September 21, 2022

RE: Mack Townhomes - 1st Technical Review Comment Letter

Please refer to our responses below which address all review comments received from you via email on July 11, 2022. You will find the markup comments listed in the order that they were written followed by our response in *italics*.

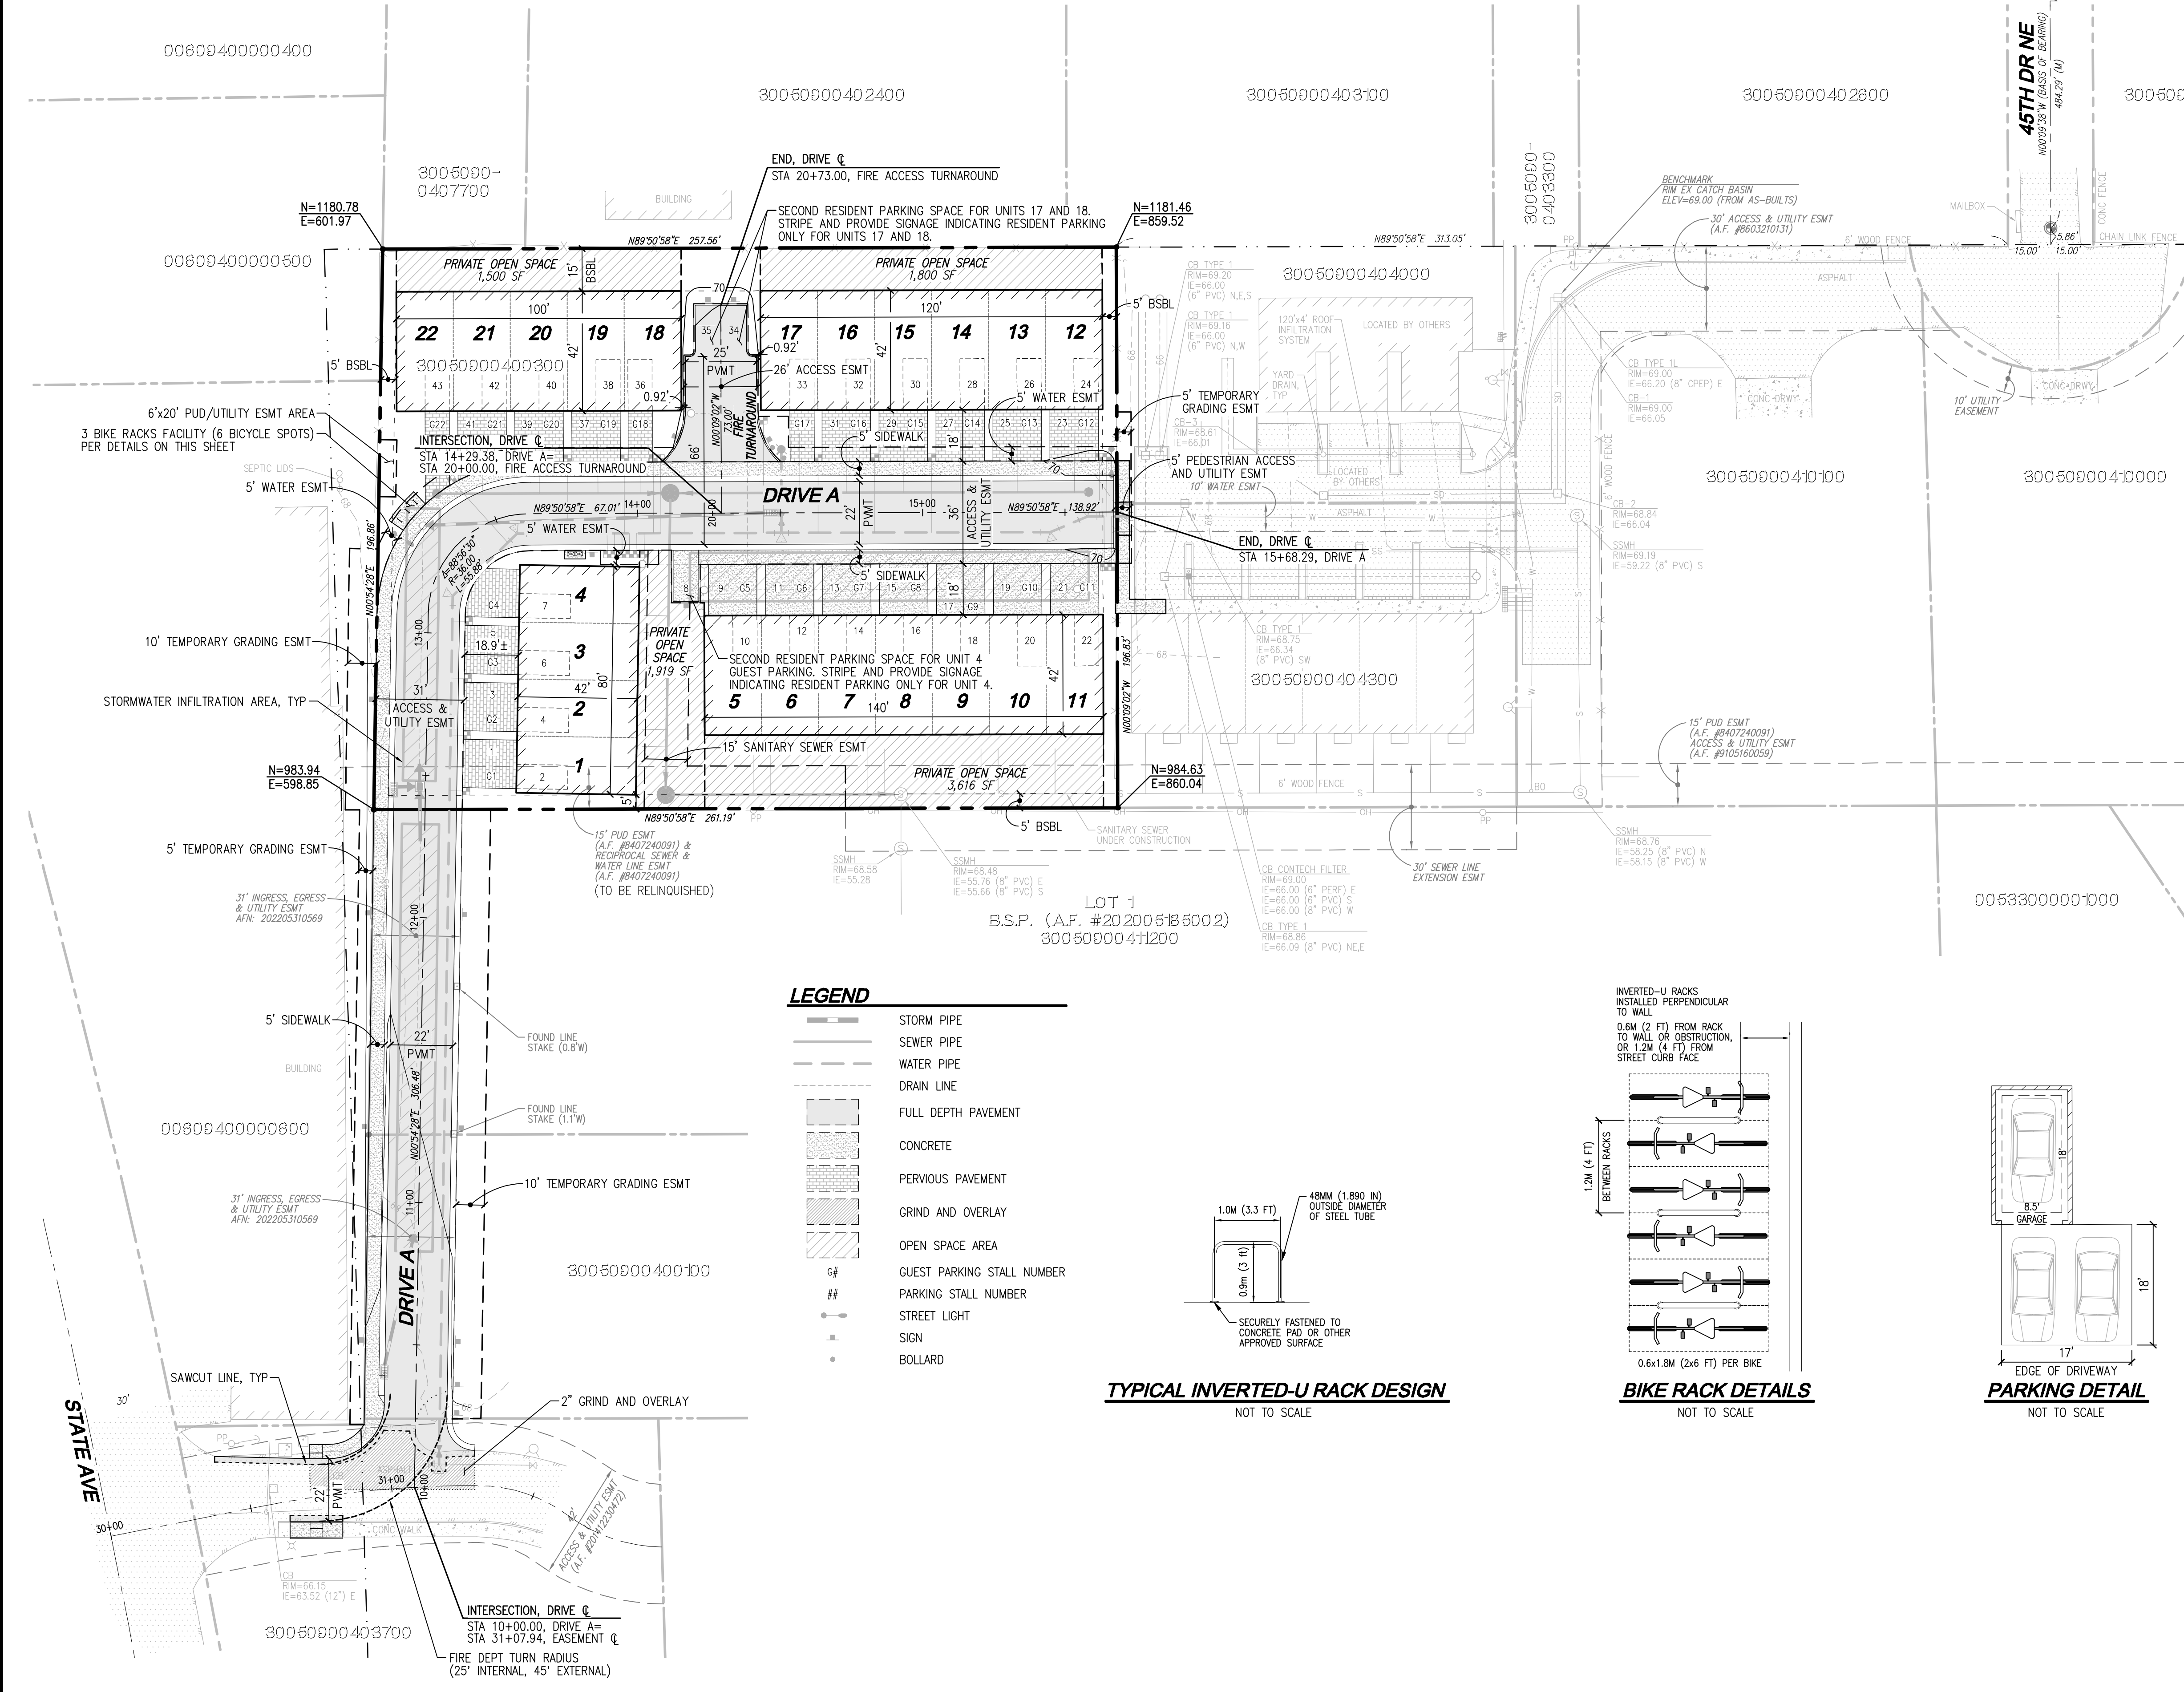
1. The Pedestrian pathway connections to the development to the east do not connect to the walkways of the development currently under construction. Please see redline site plan attached for suggested revisions to ensure connection of ped. paths between developments.

Response: A connection has been shown to the project to the east as requested.
